Date: September 25, 2026
To: Jen Uhler, Planning and Community Development Department
From: Nancy Prieve, Environmental Division, Community Resources Department
Subject: 19225 Ellicott View Rezone for Blue Springs Meadow Sub P2613

The El Paso County Environmental Division has completed its review of the 19225 Ellicott View Rezone for Blue Springs Meadow Sub P2613. Our review consisted of the following items: wetlands, federally listed threatened or endangered species, general wildlife resources, migratory birds and noxious weeds.

BLUE SPRINGS MEADOW
EL PASO COUNTY
ZONING MAP
NE 1/4 & SW1/4 SECTION 8 TOWNSHIP 12 RANGE 63

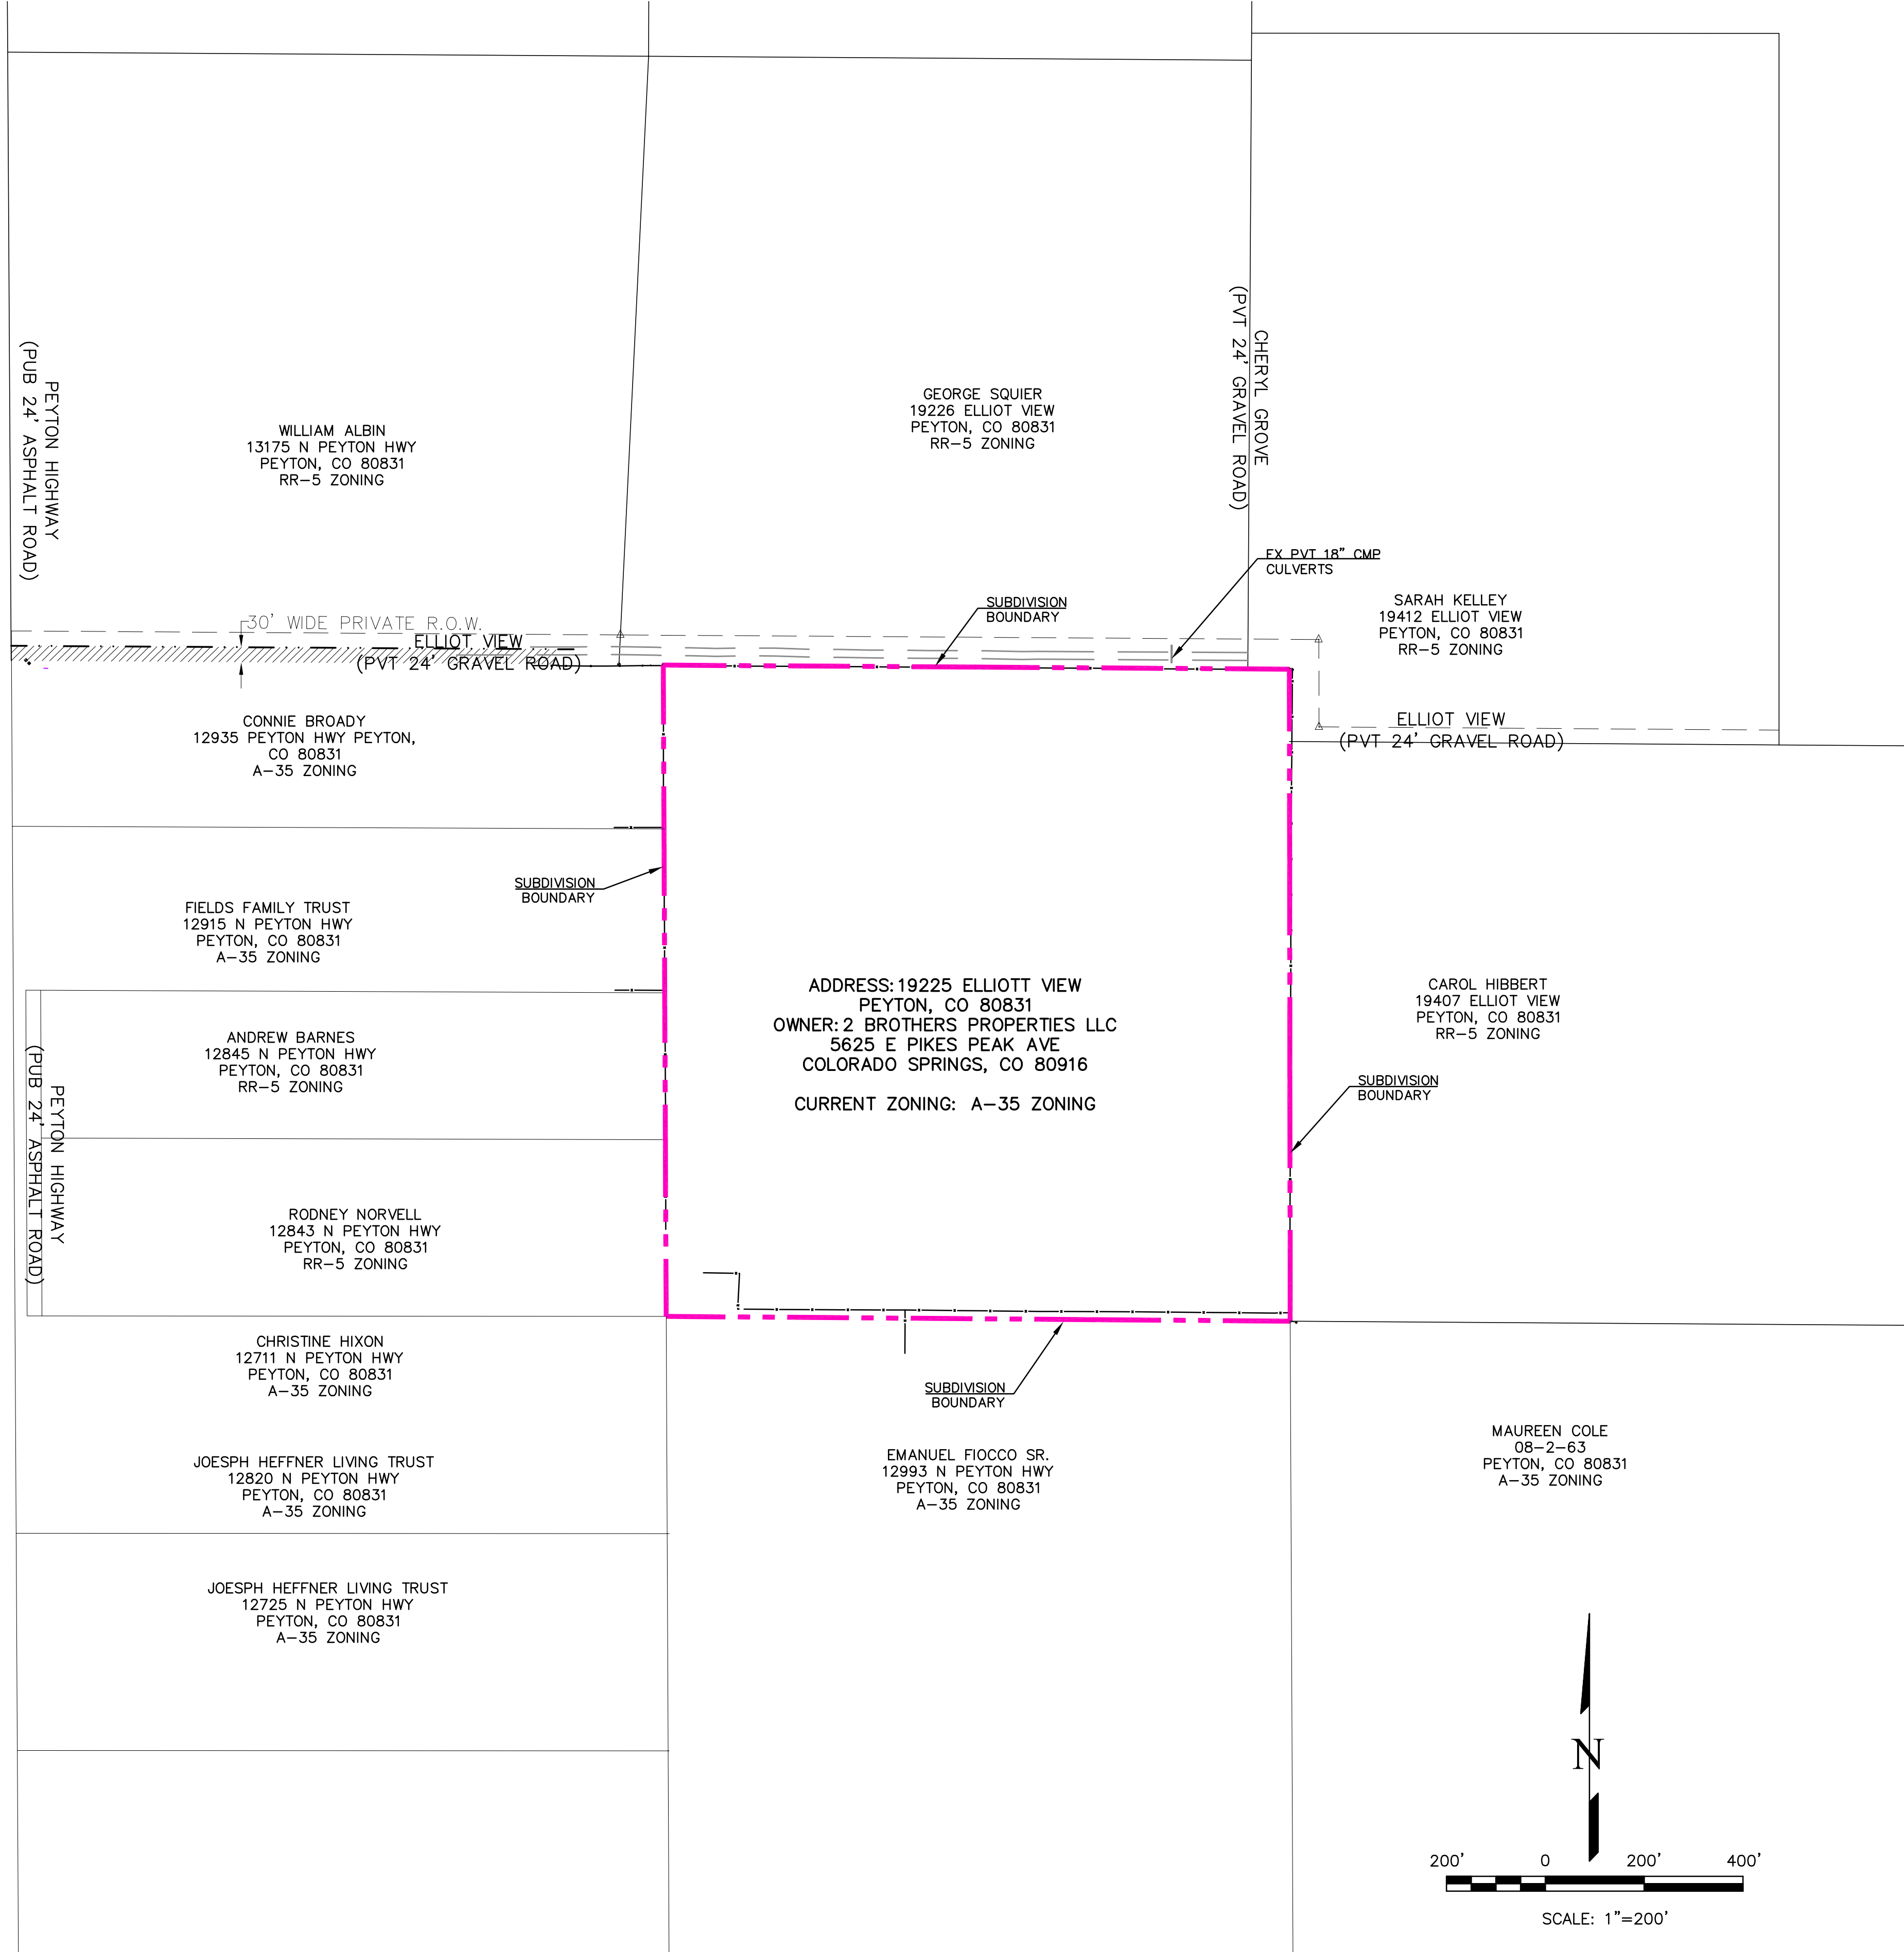
1. It appears that the property may contain more wetlands than what is indicated in the National Wetlands Inventory mapping. Be advised that wetlands-related permitting is based upon what is present on-site and not just mapping. Further, it appears that ground disturbing activities may be planned in wetland areas. General agency comments from the U.S. Army Corps of Engineers (USACE) or a completed USACE permit shall be provided to the Planning and Community Development Department prior to project commencement if ground-disturbing activities will occur in intermittent, perennial, or wetland aquatic resources. Documentation from the Colorado Water Quality Control Division (WQCD) shall be provided to the Planning and Community Development Department prior to project commencement if ground-disturbing activities will occur in state waters which are defined as "Any and all surface and subsurface waters which are contained in or flow in or through the state" (besides certain exclusions) C.R.S 25-8-103 (19). The applicant is hereby on notice that the USACE and WQCD have regulatory jurisdiction over wetlands and other aquatic resources. It is the applicant's responsibility, and not El Paso County's, to ensure compliance with all applicable laws and regulations, including, but not limited to, the Clean Water Act and Colorado House Bill 24-1379/Regulation 87.
